15879

Conditions of development consent for the Sydney Metro Martin Place Station Precinct SSD 9326 – South Site

Condition B5, B6 and B7 discharge request #2 – Design excellence and design integrity review

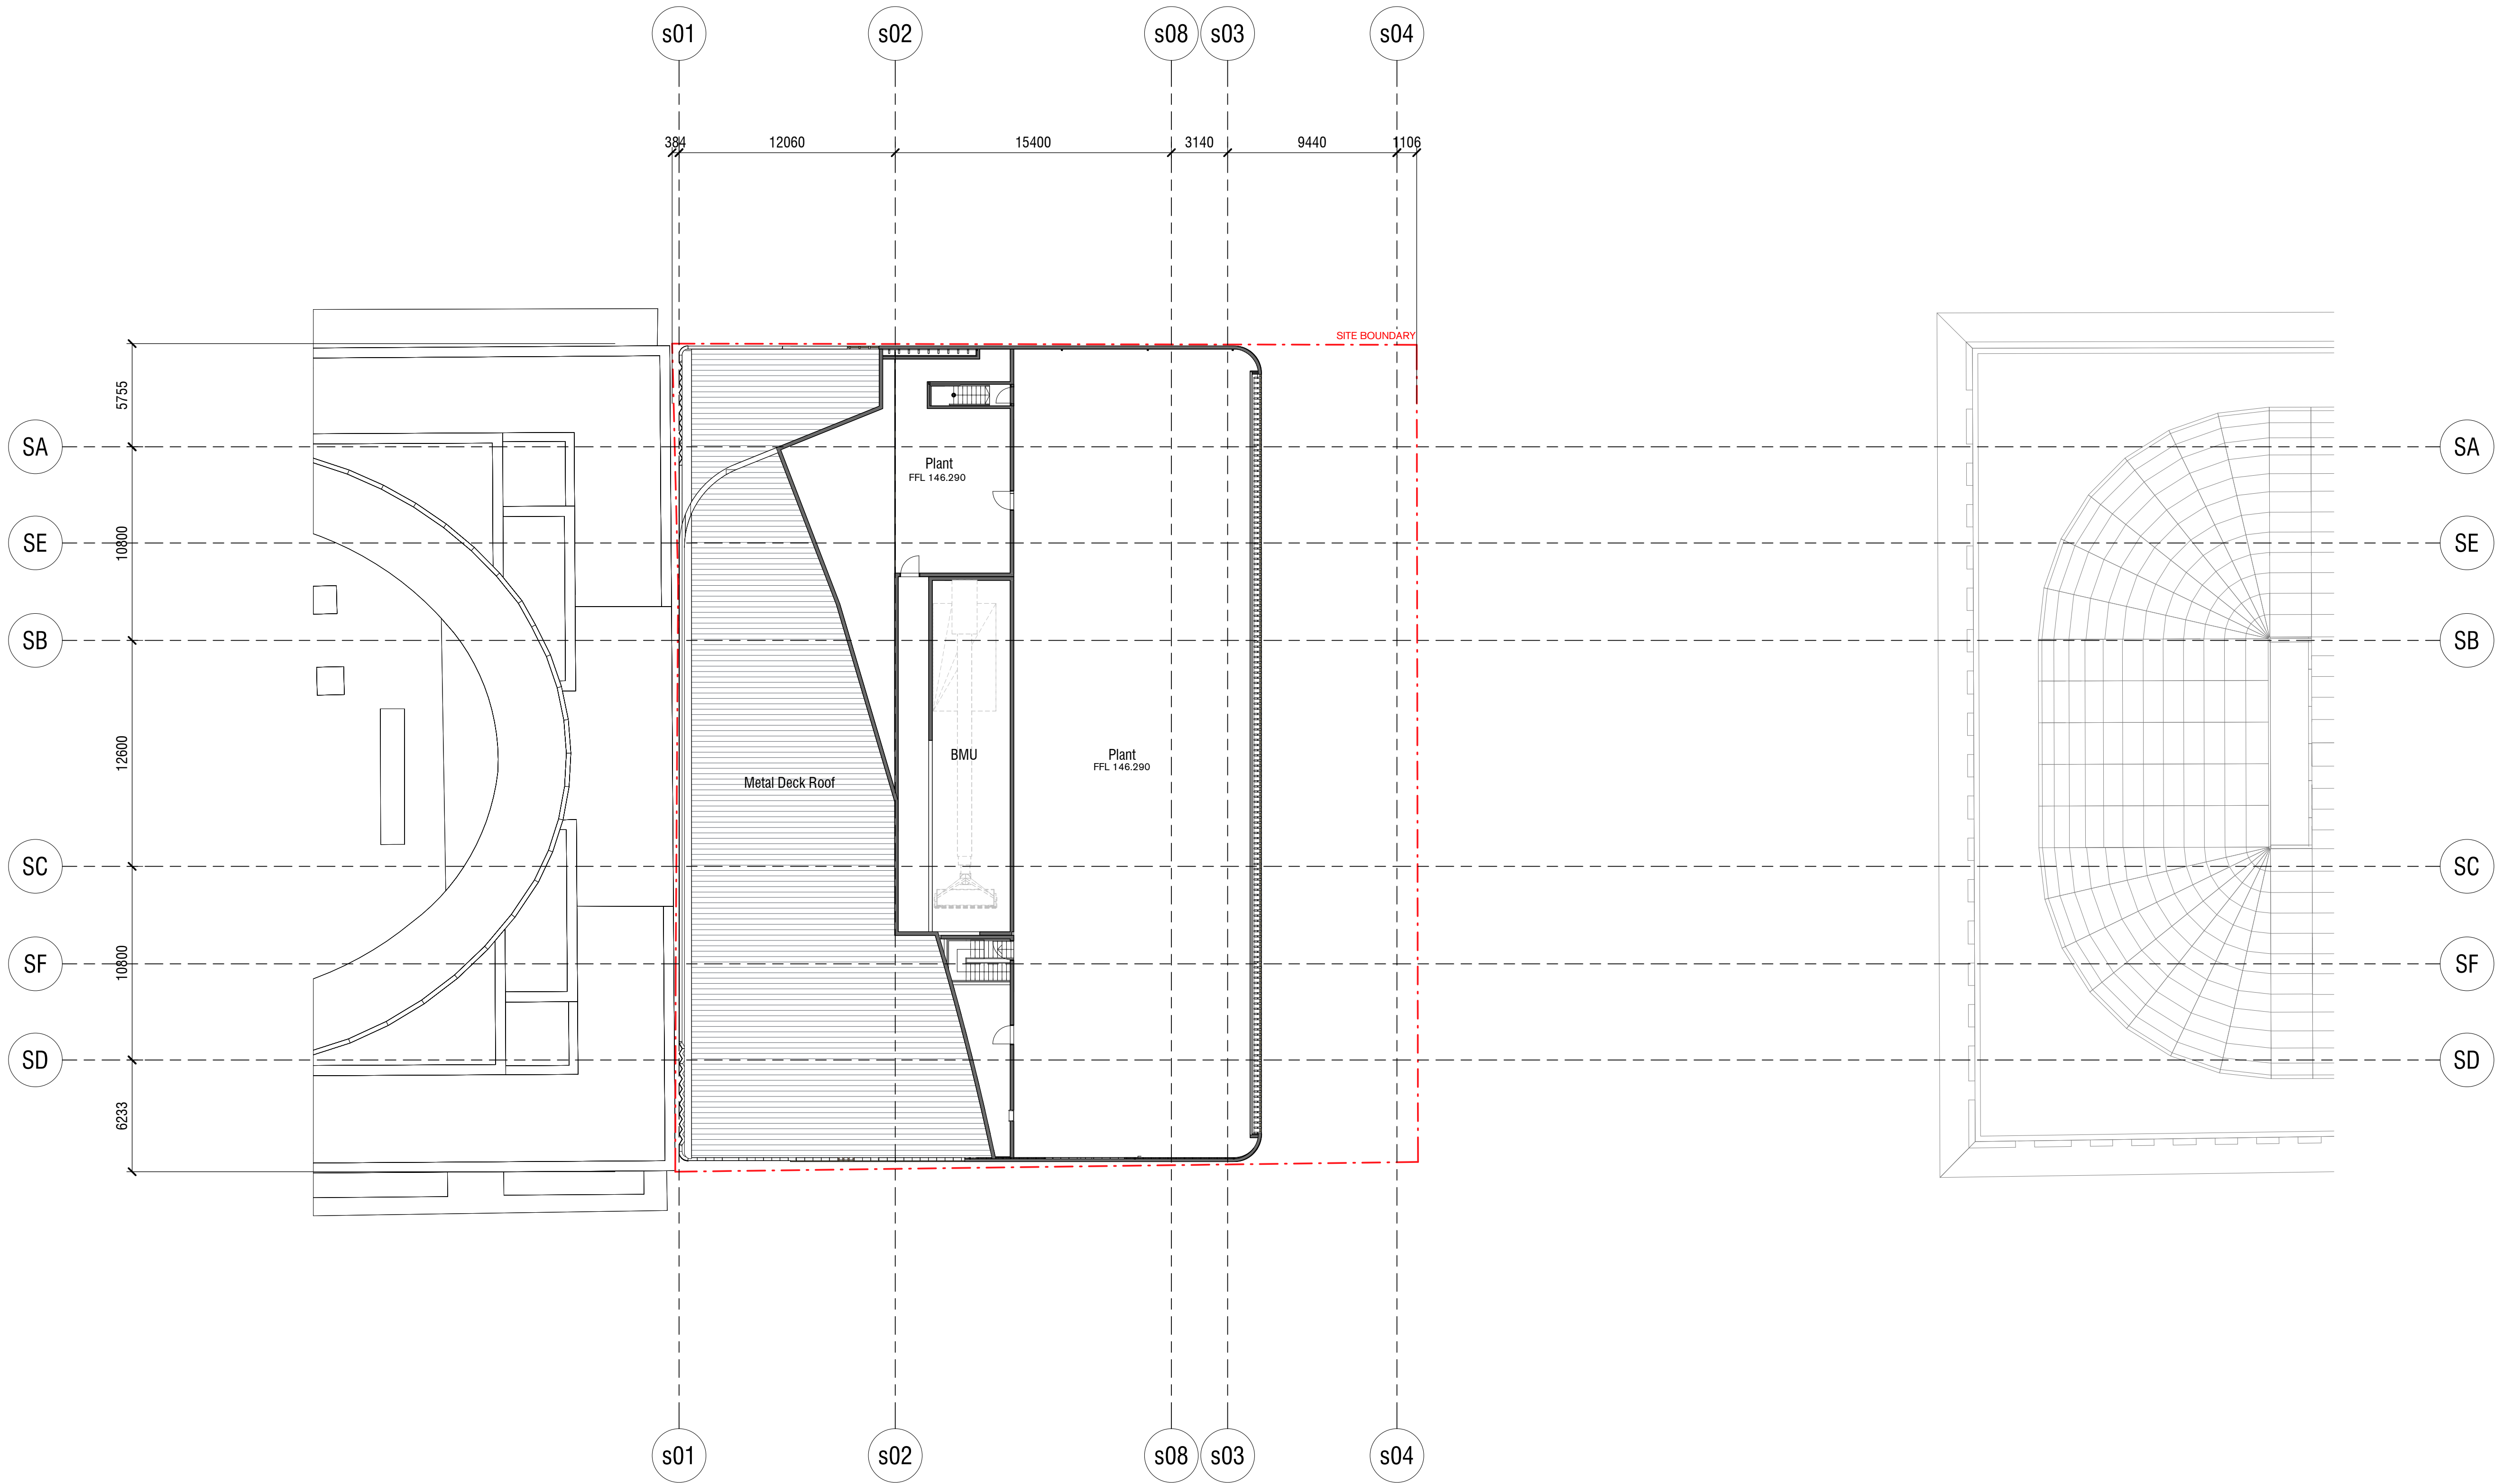
Appendix reference	Design change	OSD DRP engagement approach
App A Reference 2	Internal core changes (Level 8-27), door swing changes, handrails added on Level 9 and changes to direction of the stairs on Level 28 and 29, fixed ladder added on Level 29, in order to achieve BCA compliance.	OSD DRP review is not considered necessary on the basis that the proposed changes are wholly internal and will not result in any changes to the exterior of the building.
App A Reference 3	Services coordination: Plant room layout changes on Level 28 and riser and plenum reconfiguration on Levels 10-12.	OSD DRP review is not considered necessary on the basis that the proposed changes are wholly internal and will not result in any changes to the exterior of the building.
App A Reference 4	Design development: Structural wall thickening on Level 7, door relocation on Level 27 and structural detailing added to drawings, façade structure coordinated and bracing detail added for structural support of external cladding on Level 29	OSD DRP review is not considered necessary on the basis that the proposed changes are wholly internal and will not result in any changes to the exterior of the building.

Appendix reference	Design change	OSD DRP engagement approach
App A Reference 8 and Appendix B	Re-configuration of plant room, including changes to Level 29 access stairs, door swing direction change, and reconfiguration of risers (Level 28 and 29).	The proposed modifications are considered to not require review by the Over Station Development Design Review Panel (OSD DRP) as they will not alter any of the design excellence qualities of the building, given their minor nature, and given the proposed amendments will generally not be visible from the public domain.
	Ventilation louvre of west façade moved to suit plant and equipment layout.	
	Reconfiguration of plant room, including changes to Level 28 access stairs and addition of fixed ladder for roof access (Level 29).	
	Façade structure updated to incorporate steel frame support inside of building line (i.e.: rear of façade and not visible from the public domain) (Level 29).

Drawing Title
Roof Plan

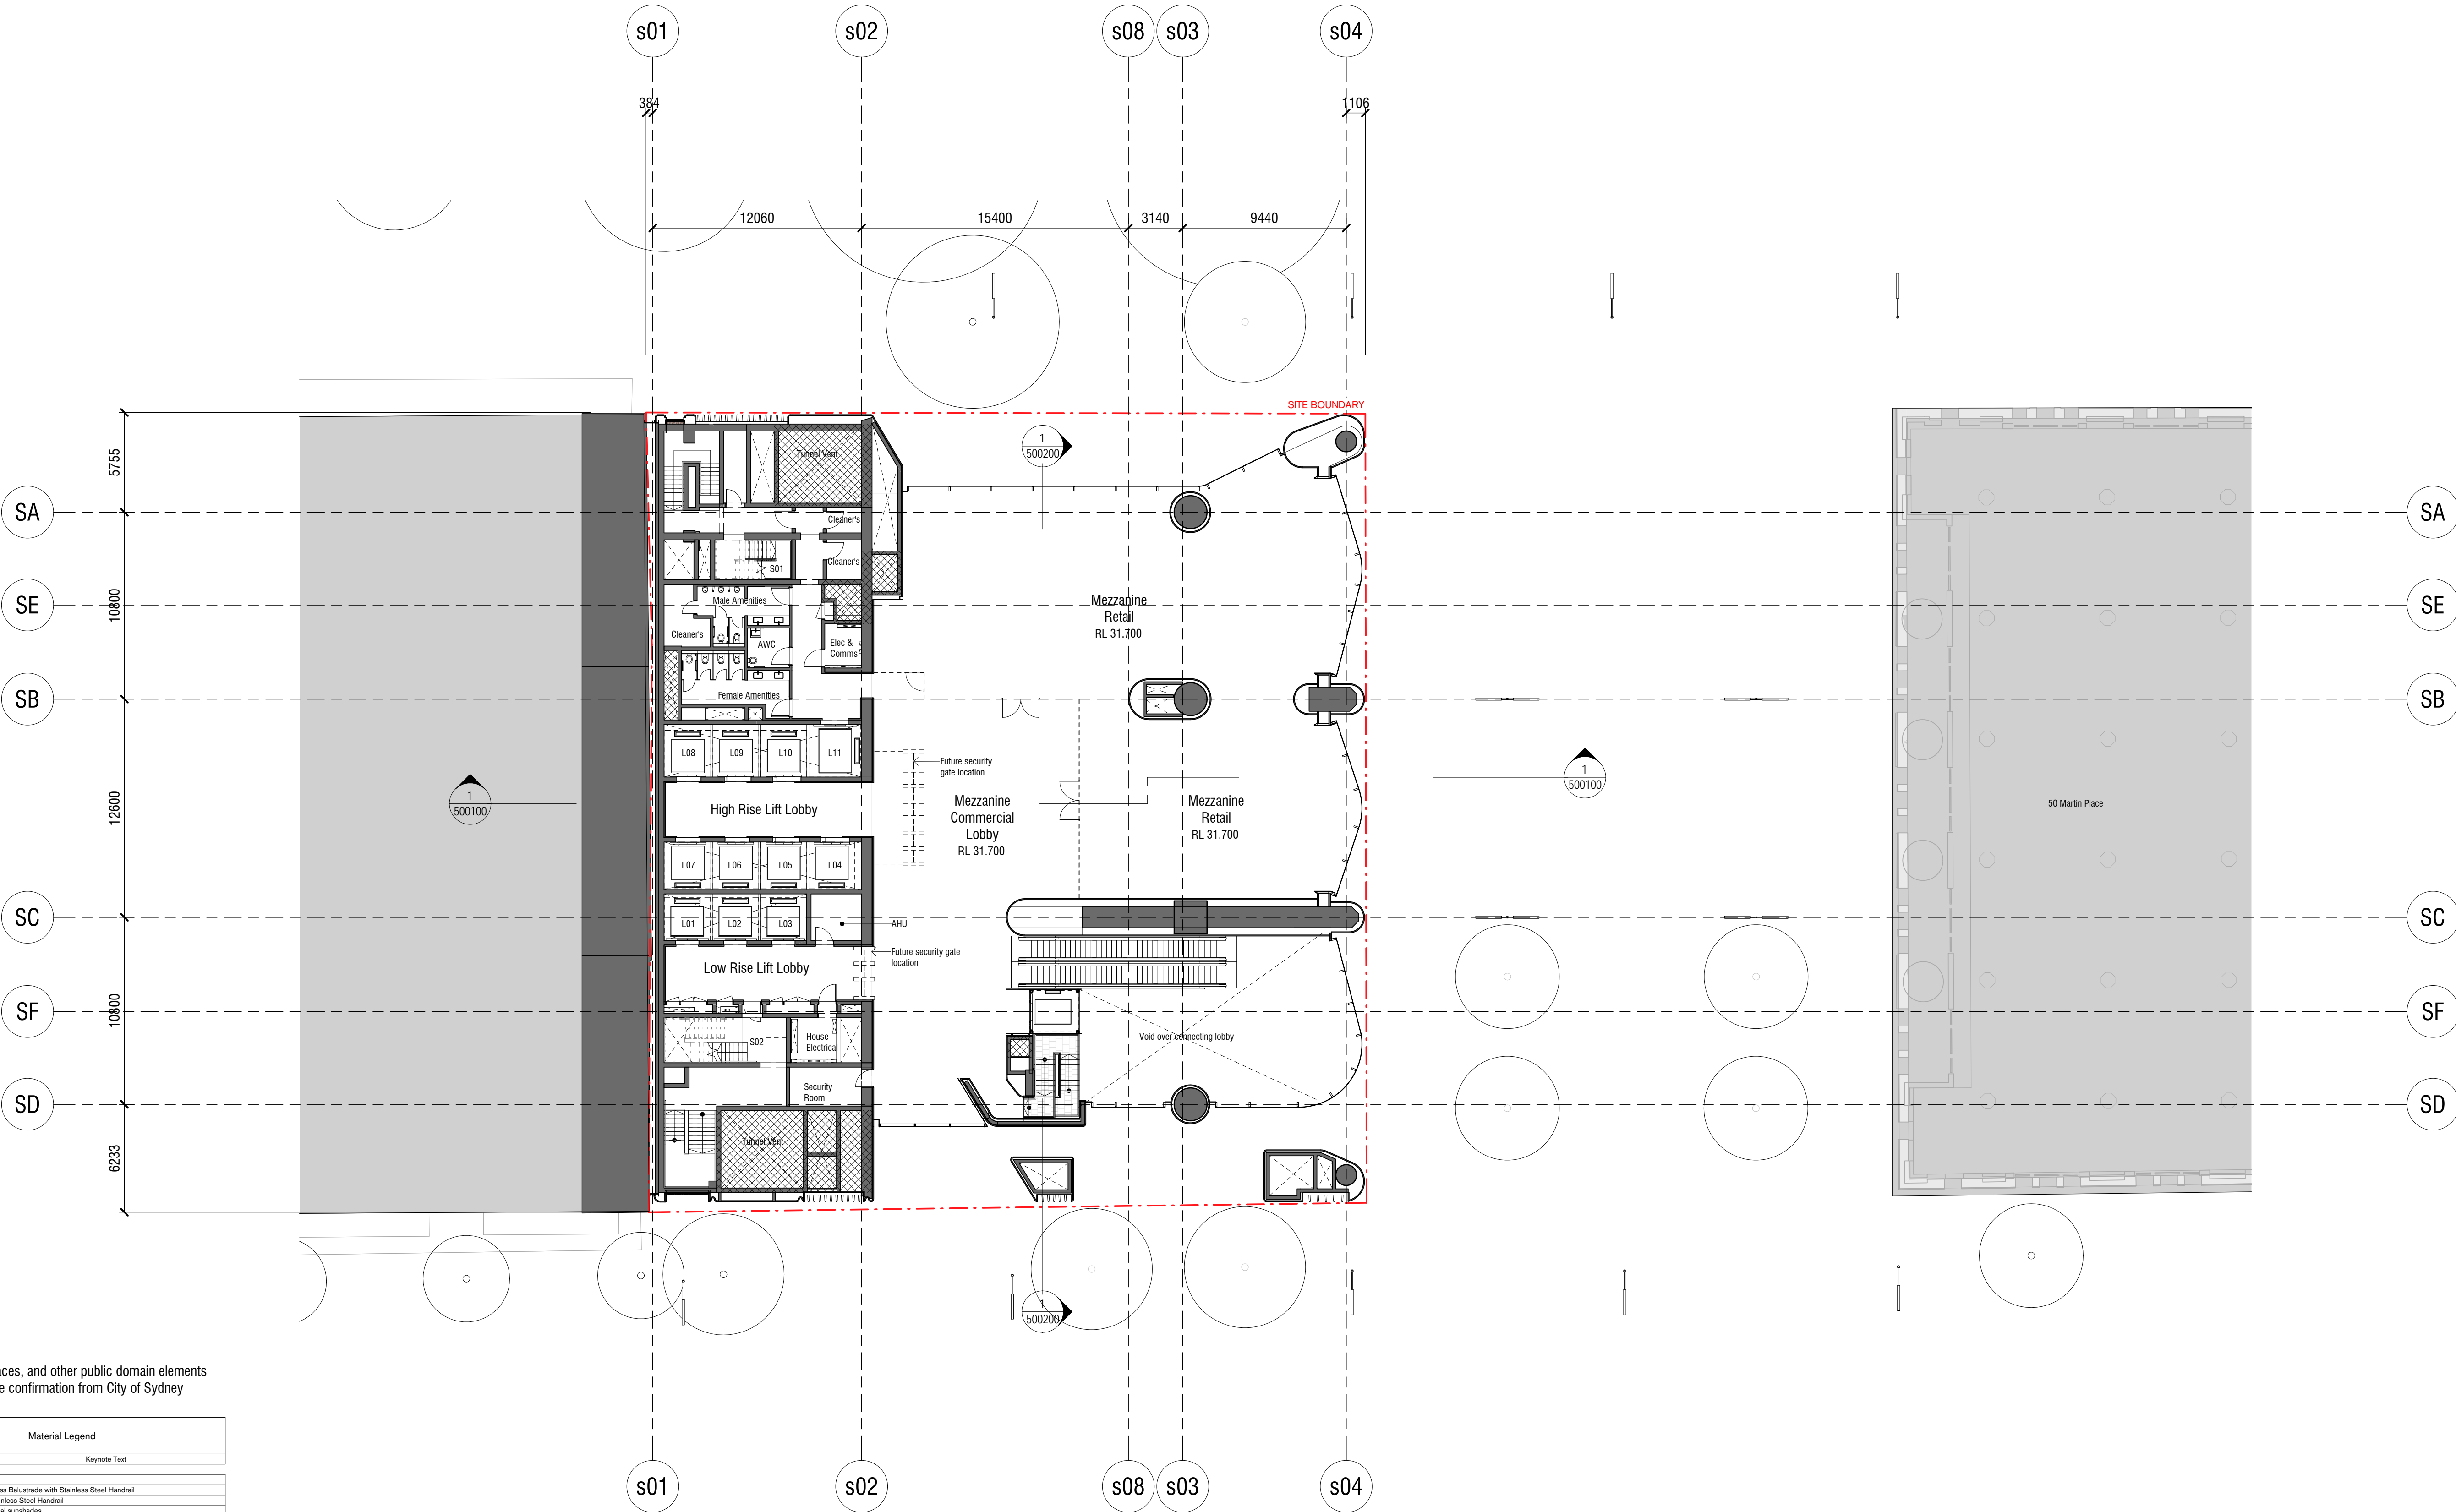
Deletion of building maintenance unit (BMU) housing north wall to accommodate equipment clearances and operation.	
	Addition of ridge lines to roof profile to reflect irregular levels and required falls to drainage with adjustments to gutter lines to suit.	
	Adjustment of exhaust outlet locations
